Aylesbury Area

Application for Removal or Variation of a Condition following Grant of Planning Permission or Listed Building Consent

Householder application for single storey rear extension, first floor side extension and facade alterations

22/02644/APP

Client	
		Mr and Mrs Warburton	
Job Title		Date	
Proposed Extension and Internal Alterations		March '22   1:100@A3	
12 New Road, Aston Clinton, HP22 5JD		Drawing Title	
Elevations		AT 160	
As Proposed		Drawing No	
		PD 06	
		D

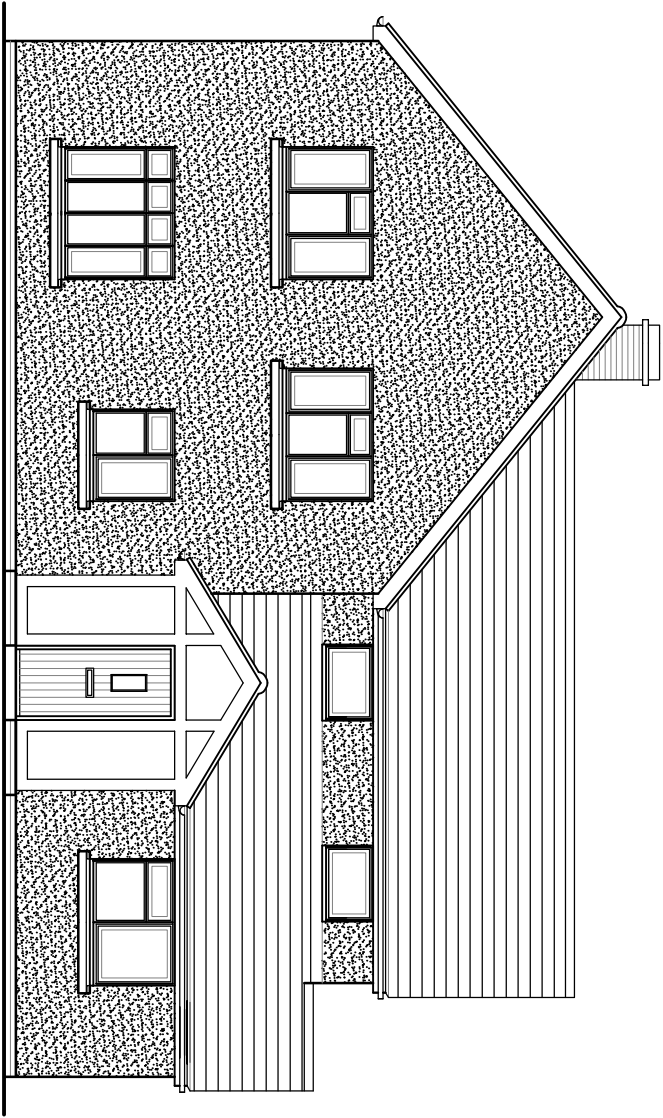
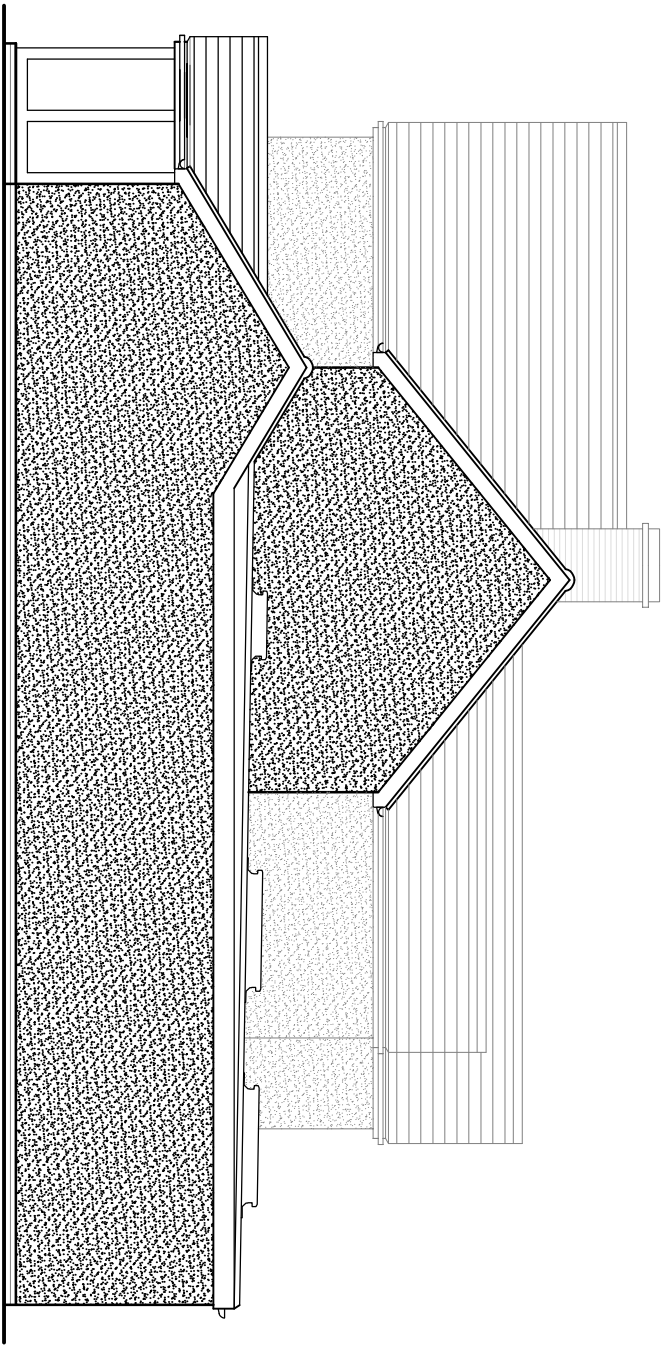
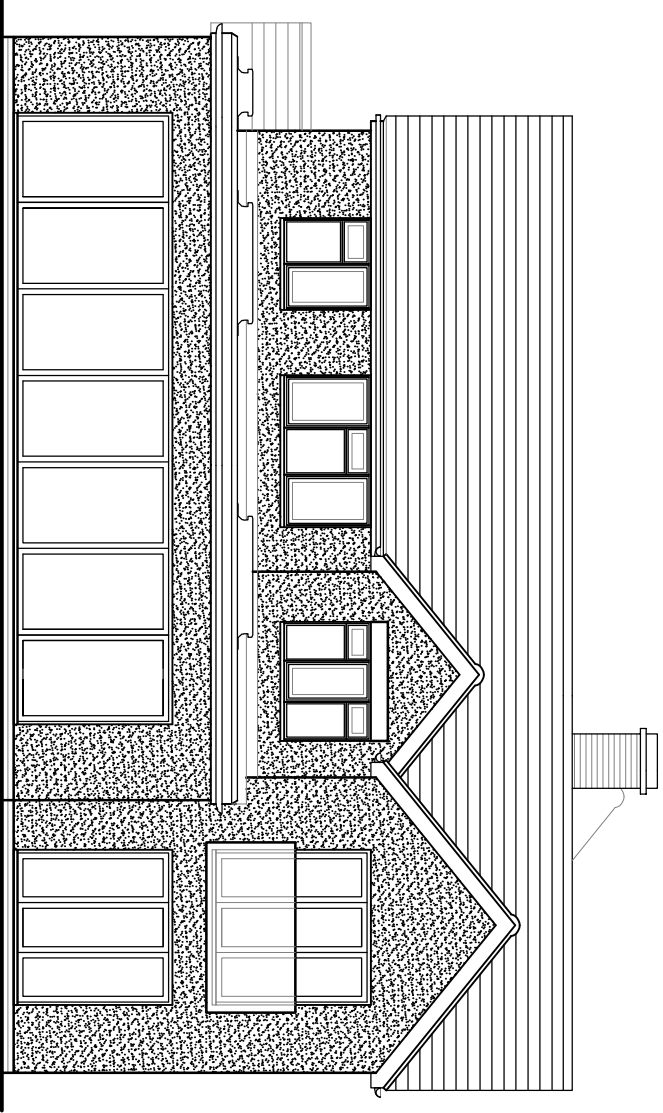
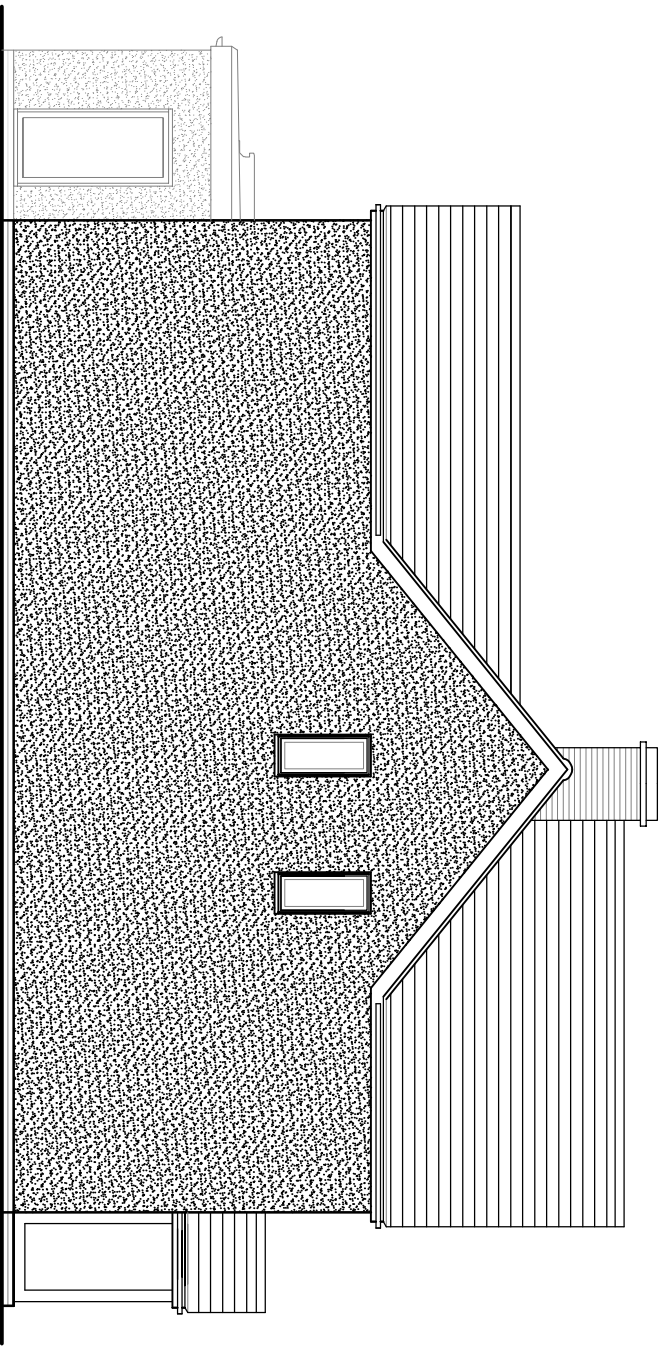
- Slight increase in footprint of single storey element to the rear (extending out to existing side wall line),
- Roof of single storey element raised slightly to accommodate structure ensuring ceiling is flush/level with existing
- Study window to the front made wider
- Facade treatment changed from Cedral OEA to render with recon stone cills to the widows on the front elevation
- Minor amendment to porch design

Condition 3 varied to specify materials as listed on above drawings, not as application form (change of proposed facade treatment)
